**Consultation Response from KC,
Trees**
2020/93678 5, Knowl Park Gardens, Mirfield, WF14 9FF
Erection of detached building for home work/storage and removal of one protected tree
Date Responded:21/12/20 Responding Officer:JR Responding Ref: TPO 23/92

DRAWING TITLE	BLOCK PLAN
DRAWING NUMBER	DRG-KPG-202
APPLICANT NAME	MR & MRS MORTIMER
APPLICANT ADDRESS	5 KNOWL PARK GARDENS MIRFIELD, WF14 9FF
PAPER SIZE	A3
DRAWING SCALE	1:100

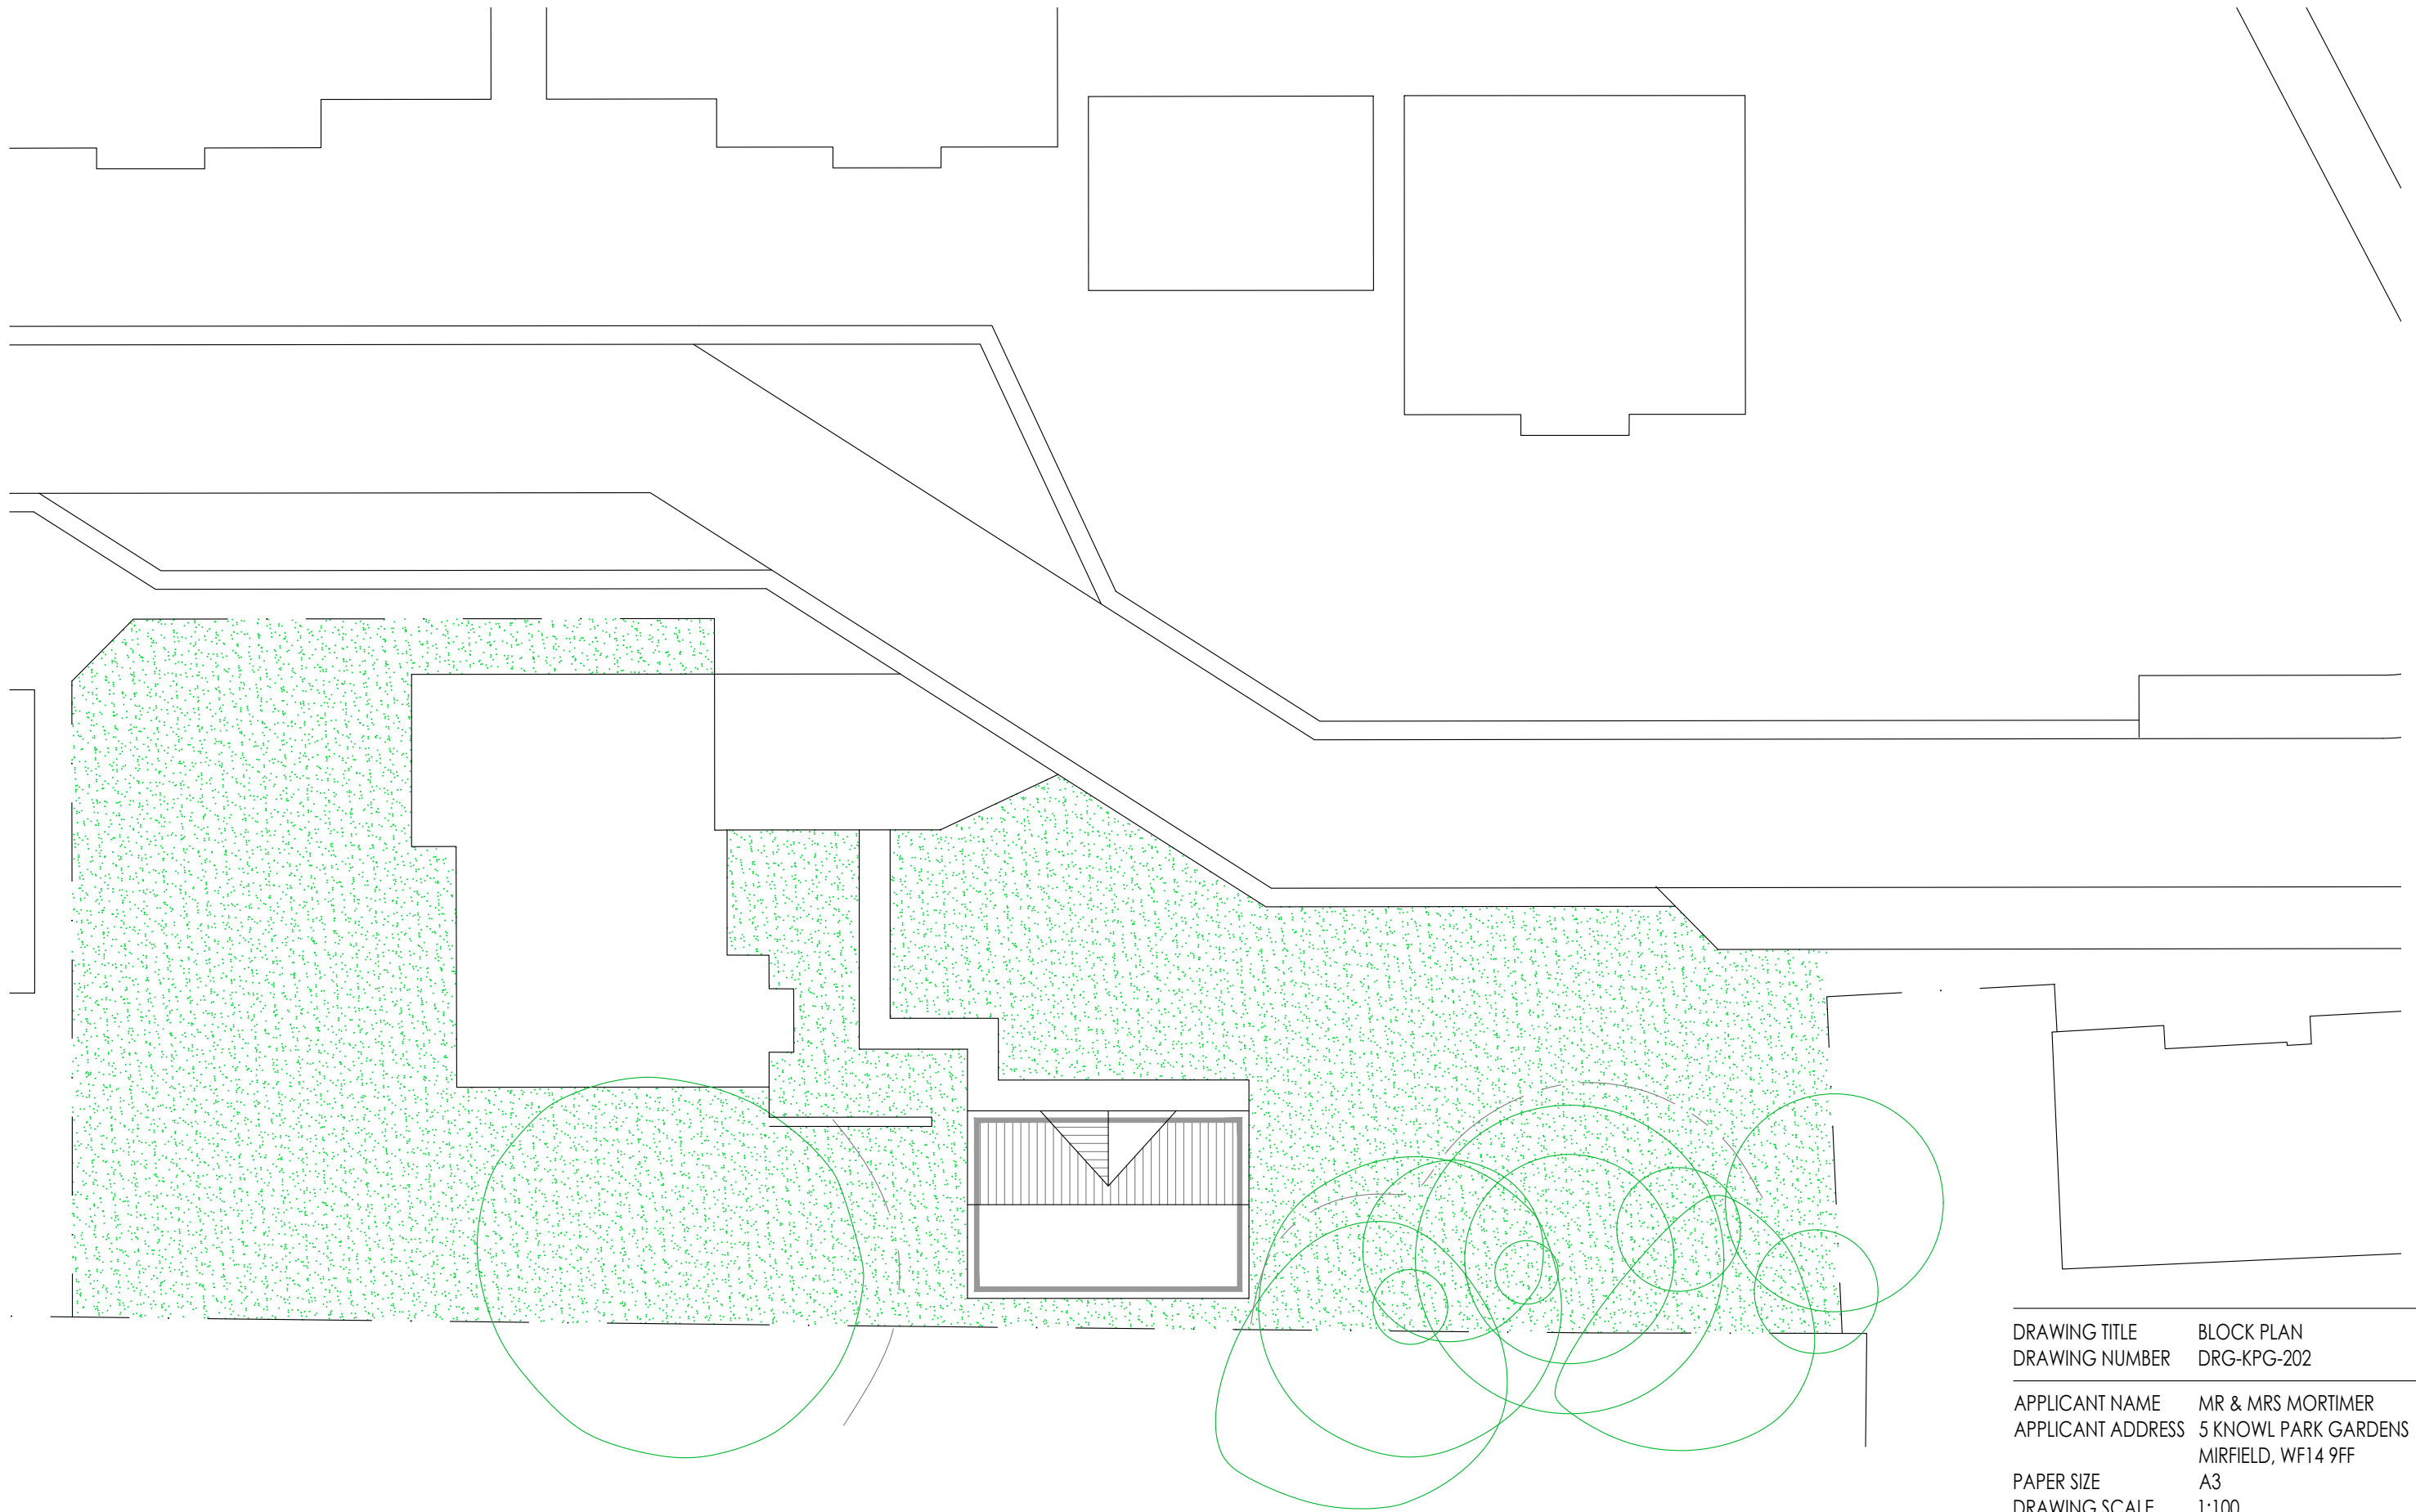
There is insufficient tree information provided with this application. Limited to a plan and text within the design and access statement that does not meet the British standard.

There is no clear evidence to show why the protected tree that is proposed for removal warrants a category C, as given in the design and access statement, rather than the higher B category given to similar, if not smaller, adjacent trees. During the site visit it was clear that this tree should be a much higher retention category. This protected tree is a prominent feature of the local setting and provides significant public amenity. Given the required loss of protected trees and insufficient tree protection measure /detail given, the proposal will have an impact on the protected trees on site.
